**City of Portland, Maine - Building or Use Permit Application**  
 389 Congress Street, 04101 Tel: (207) 874-8703, Fax: (207) 874-8716

<b>Permit No:</b> 09-0756	<b>Issue Date:</b>	<b>CBL:</b> 028 K001001
------------------------------	--------------------	----------------------------

<b>Past Use:</b> retail - art Gallery :Addison Woolley Gallery"	<b>Proposed Use:</b> retail - Install 2 - 2'-0" x 7'- 0" signs - "Deja Vu"	<b>Permit Fee:</b> \$121.00	<b>Cost of Work:</b> \$30.00	<b>CEO District:</b> 1
		<b>FIRE DEPT:</b> <input type="checkbox"/> Approved <input type="checkbox"/> Denied		<b>INSPECTION:</b> Use Group: Type
<b>Proposed Project Description:</b> Install 2 - 2'-0" x 7'- 0" signs		Signature:		Signature:
<b>PEDESTRIAN ACTIVITIES DISTRICT (P.A.D.)</b>				
Action <input type="checkbox"/> Approved <input type="checkbox"/> Approved w/Condition <input type="checkbox"/> Denied				
Signature:		Date:

MARKET ST

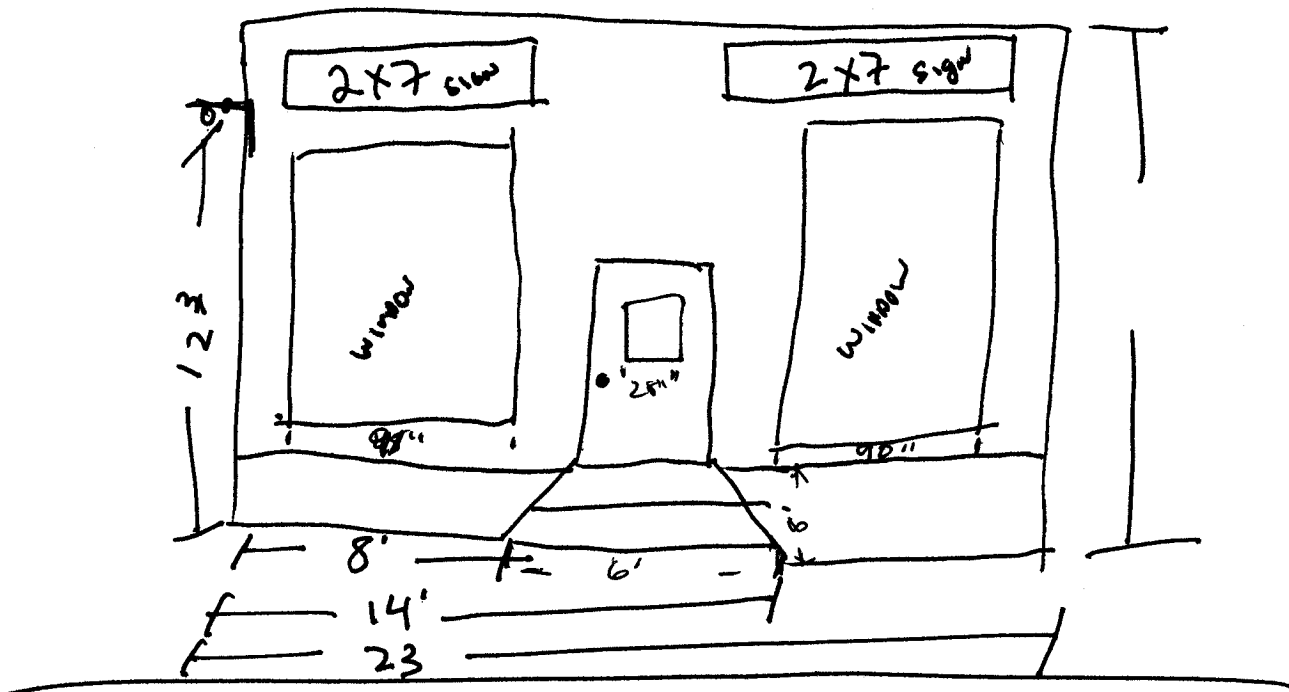
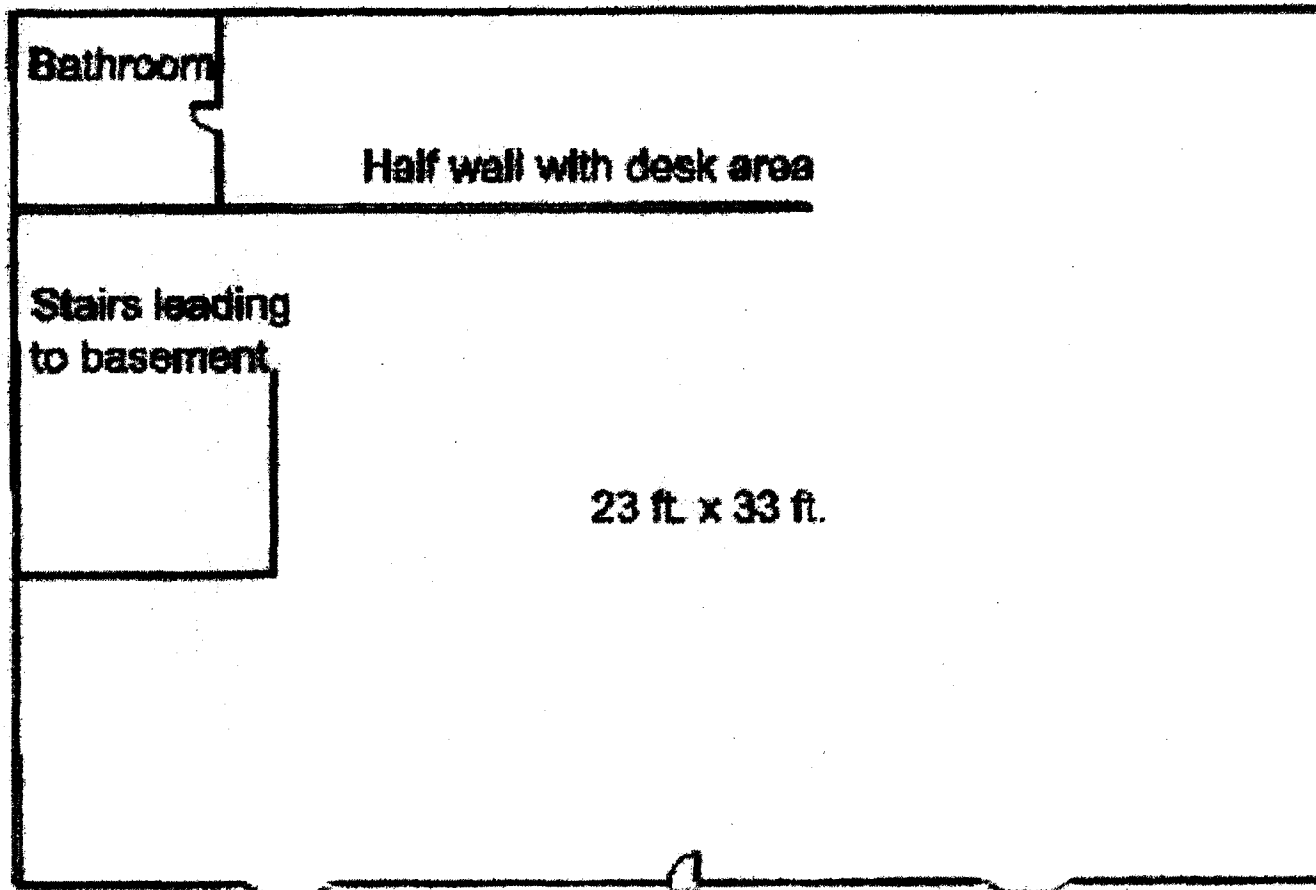
1) Signage Installation to comply with Chapter 31 of the IBC 2003 building code. 2) Encroachments into public ways must be 8' above grade as per section 3202 of IBC 2003.			
<b>Dept:</b> Planning	<b>Status:</b> Approved	<b>Reviewer:</b> Deborah Andrews	<b>Approval Date:</b> 07/23/2009
<b>Note:</b>			<b>Ok to Issue:</b> <input checked="" type="checkbox"/>

**Comments:**  
7/21/2009-amachado: Only allowed one sign on the building per section 14-369.5, Table 2.8. Gave permit to planning under section 14-368.5(g).

↑ PHONE #
TO CHANGE

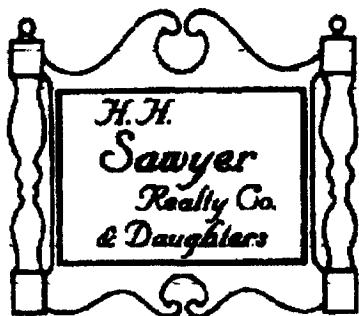
1) * The two sign panels to match each other in all respects, including graphics. * Phone number to be eliminated from sign panels.			
<b>Dept:</b> Zoning	<b>Status:</b> Approved	<b>Reviewer:</b> Ann Machado	<b>Approval Date:</b> 07/23/2009
<b>Note:</b> Deb Andrews approved it on 7/23/09 under section 14-368.5(g).			<b>Ok to Issue:</b> <input checked="" type="checkbox"/>
<b>Dept:</b> Building	<b>Status:</b> Approved with Conditions	<b>Reviewer:</b> Chris Hanson	<b>Approval Date:</b> 07/27/2009
<b>Note:</b>			<b>Ok to Issue:</b> <input checked="" type="checkbox"/>
